Site 3 Residential Development – Land Owners Consent – Stages 2 & 3 Draft Environmental Assessment

SOPA has reviewed documentation provided by Architectus, dated April 2011 for the proposed development of Site 3 – Stages 2 & 3, Australia Avenue, Sydney Olympic Park.

Figure 4.10 - Plans showing staging of construction

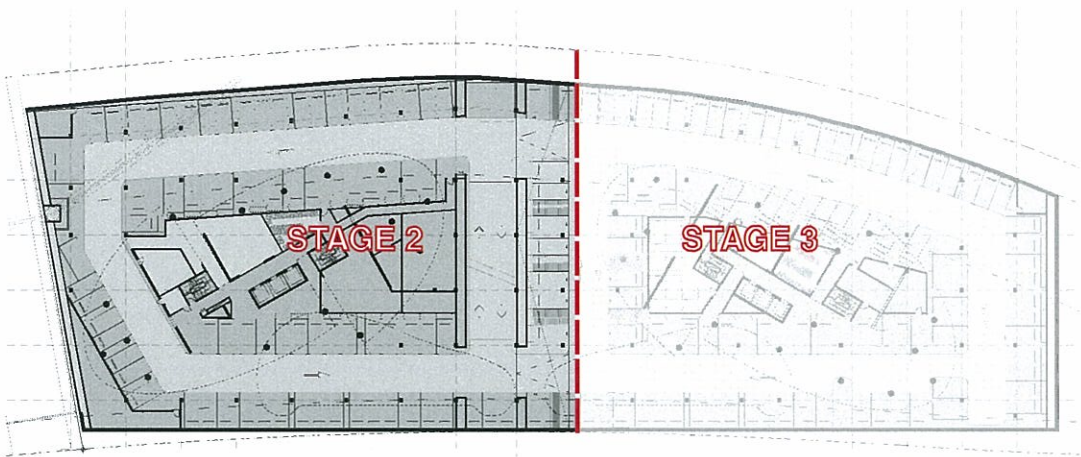
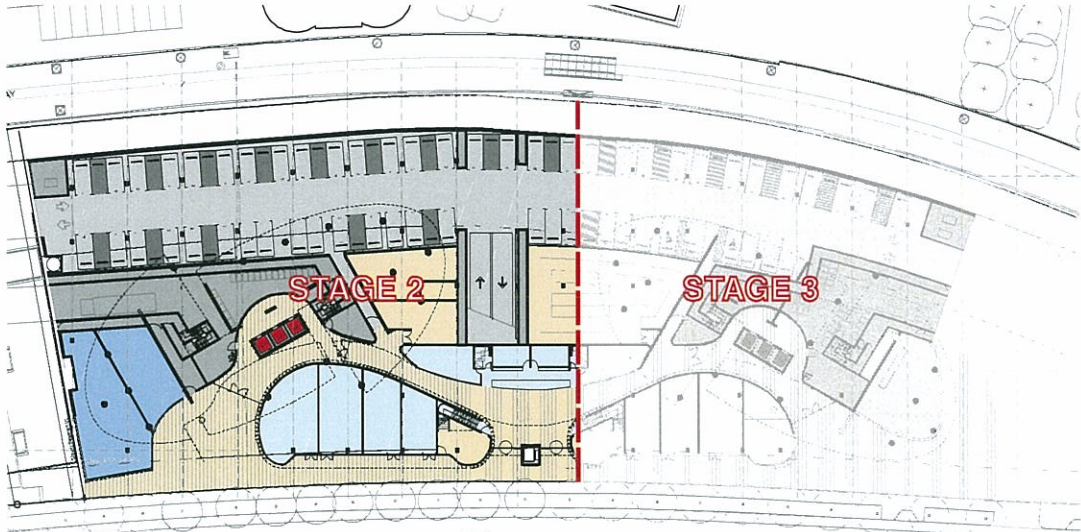
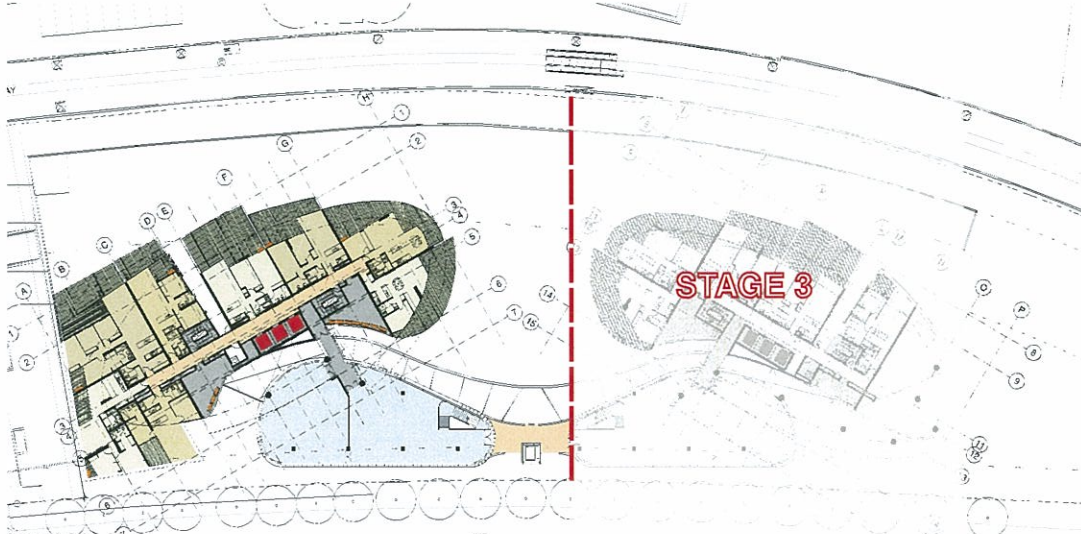
- The EA fails to address clause 21 – Exceptions to Development Standards of the SEPP (Major Development) 2005. This is the mechanism by which the consent authority can vary the development standard and the proposal exceeds both the FSR and height controls. Clear justification needs to be made as to why the development standard should be varied in each instance. For example, the height control is exceeded by 9 metres. To assist with understanding the FSR distribution across Site 3, it would be useful to provide a table of site area, GFA and FSR in relation to Stage 1 and Stages 2/3.
